Office of Environment & Heritage

Your reference: SSD-5012
Our reference: DOC13/27049
Contact: Peter Ewin 03 5021 8915

Re: Exhibition of Environmental Impact Statement for Atlas-Campaspe Mineral Sands Project (SSD-5012)

Attachment A: OEH Comments on and Recommendations for the Atlas-Campaspe Mineral Sands Project EIS

Figure 8: Vegetation Communities – Atlas-Campaspe Mine

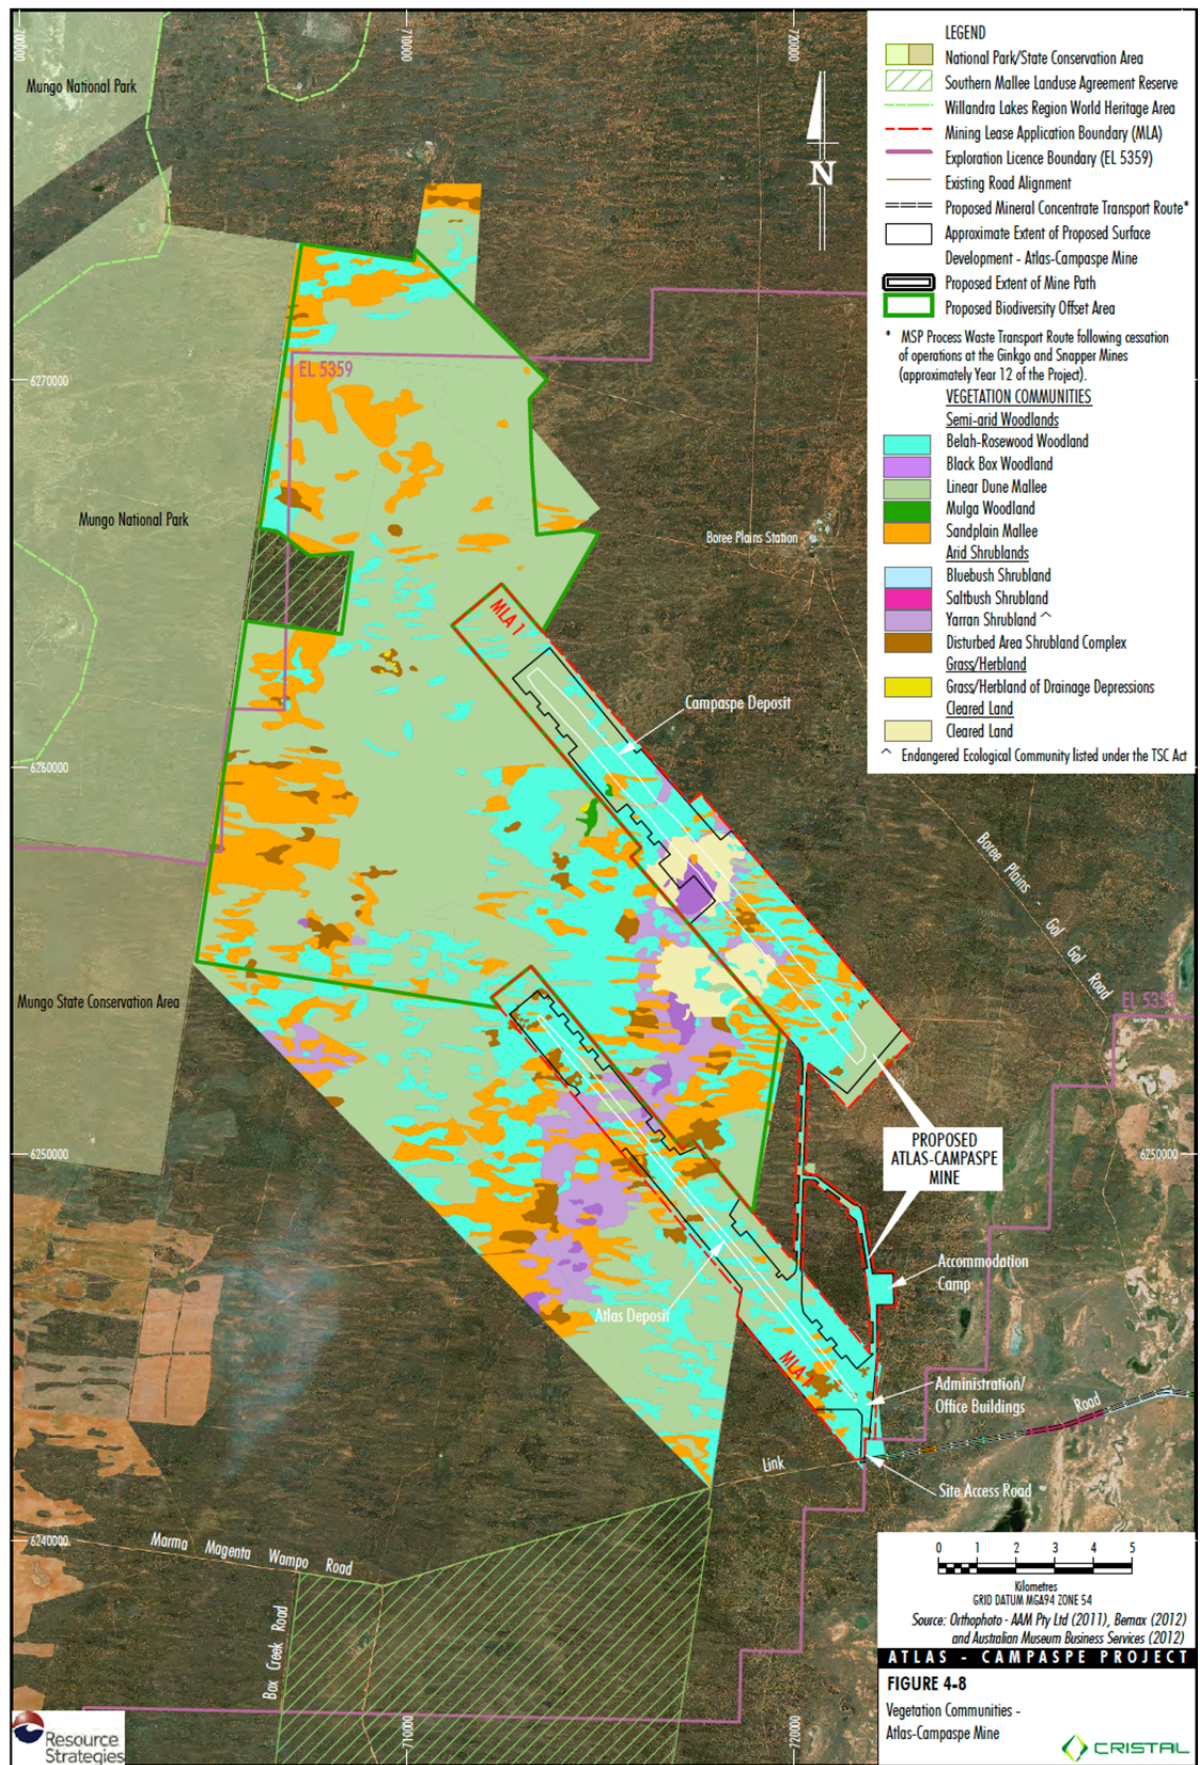
The analysis of the vegetation data collected, the presentation of community profiles and the associated vegetation map are thorough and of high quality (Pages 46-72 of Appendix A). However, there are a number of concerns with the process and the resulting vegetation map detailed in Figure 11 (Figure 4-14 of the Main Report) that make it difficult to fully assess the impacts of the proposal:

- The decision to only survey (and map) the development footprint and the proposed offset limits the detail on the extent of the vegetation communities within the area and also the potential impacts of the clearing of this vegetation in a local context. The lack of mapping to the north of the Campaspe deposit and to the east of both deposits (particularly in the area surrounding the accommodation camp and connecting roads) is particularly important. Figure 8 gives an indication of the regional vegetation communities present, but this does not provide the level of detail required to fully assess the impacts of the proposed development.

- Vegetation mapping of the Southern Mallee Area (Val, 2001) detailed significant areas of the study area, particularly the northern extremity of the Campaspe mine path and the northern half of the proposed offset, as Deep Sand Mallee (which is identified a separate community from East West Dune Mallee in the NSWVCA (172)). Though both these communities are discussed in the EIS they are lumped together in the vegetation mapping. Further information on the extent of this community should be provided, as the assumption is that the two communities did not separate in the analysis due to lack of sites within the northern mallee areas, as there are implications for threatened fauna species which potentially have different usage of the these two communities.

Undertake vegetation mapping in the areas to the east of the proposed development footprint.

*Further discussion on the area and extent of some vegetation communities (particularly Deep Sand Mallee and Black Oak-Pearl Bluebush Woodland) needs to be added, as does further consideration (and mapping) of the Belah-Rosewood/*Acacia* Woodland present at the Ivanhoe facility.*

Figure 11: Proposed Biodiversity Offsets and Vegetation Management Areas

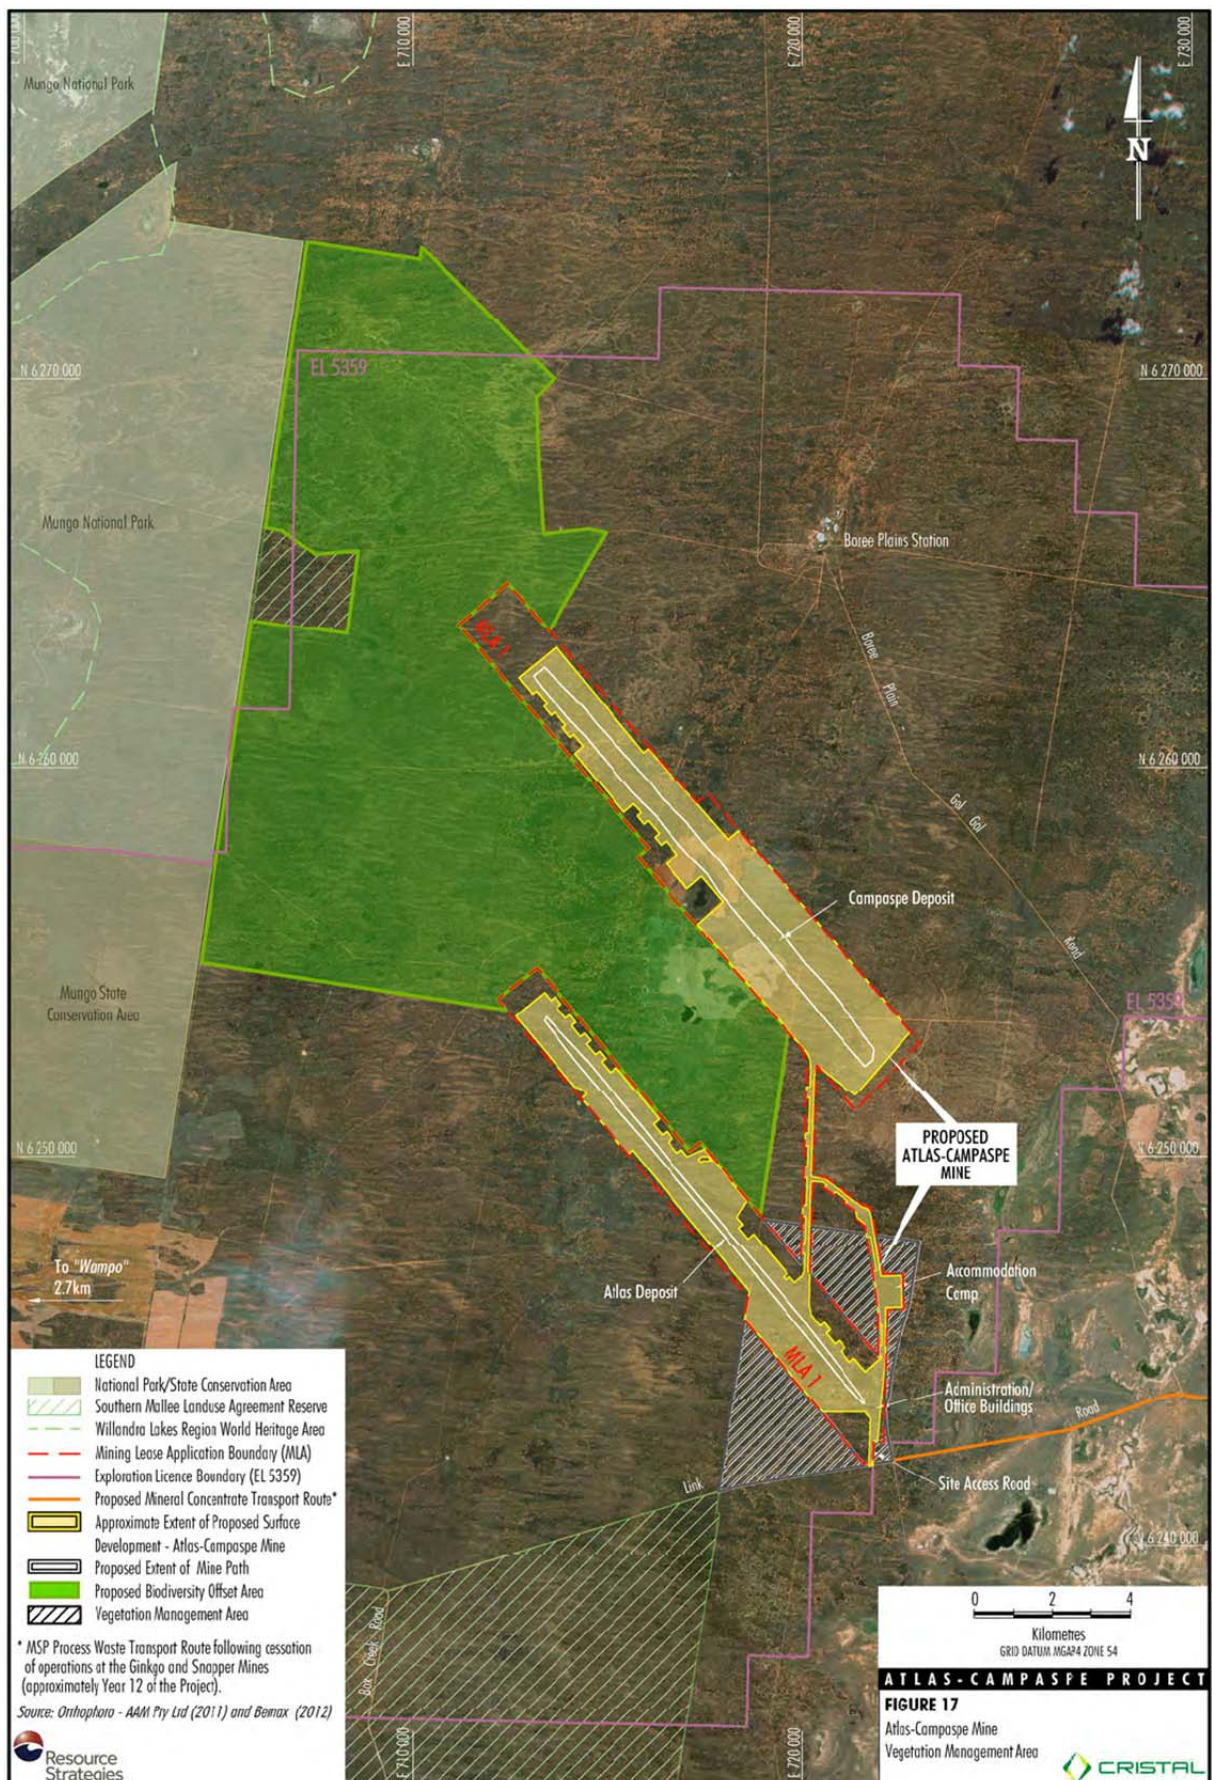
We have a number of concerns regarding the proposed offset as identified in Pages 107-120 of Appendix A. We do not believe the area identified is sufficient to mitigate the impacts of the proposed development, though this is difficult to quantify as the proponents have not utilised an assessment methodology (such as the BBAM as recommended in our correspondence) that allows a quantitative evaluation of the biodiversity values of the offset. The main concerns are location, area and vegetation composition, though the issues raised above in regard to the assessment undertaken (i.e. extent of vegetation mapping and condition identification) also make it difficult to assess the appropriateness of the proposed offset.

While a number of the criteria identified on Page 107 of Appendix A in regard to selection of the offset are valid, including proximity to both the mine site and existing conservation reserves, and the location of existing tracks and fencelines, other selection criteria identified are less so. Particularly, there is no requirement that limits the offset to '*Cristal Mining controlled land*'. The entire area within the Boree Plains Station has not been mapped or considered as the offset, indicating that the location of offset land is restricted to areas that do not contain further potential mineral resources (a consideration which has not been included in the EIS). While any proposed offset must be able to be managed for that purpose in the long term, we also do not believe mineral prospect within the area of this proposal should limit the area of the offset, if sufficient 'sterile' areas are not available.
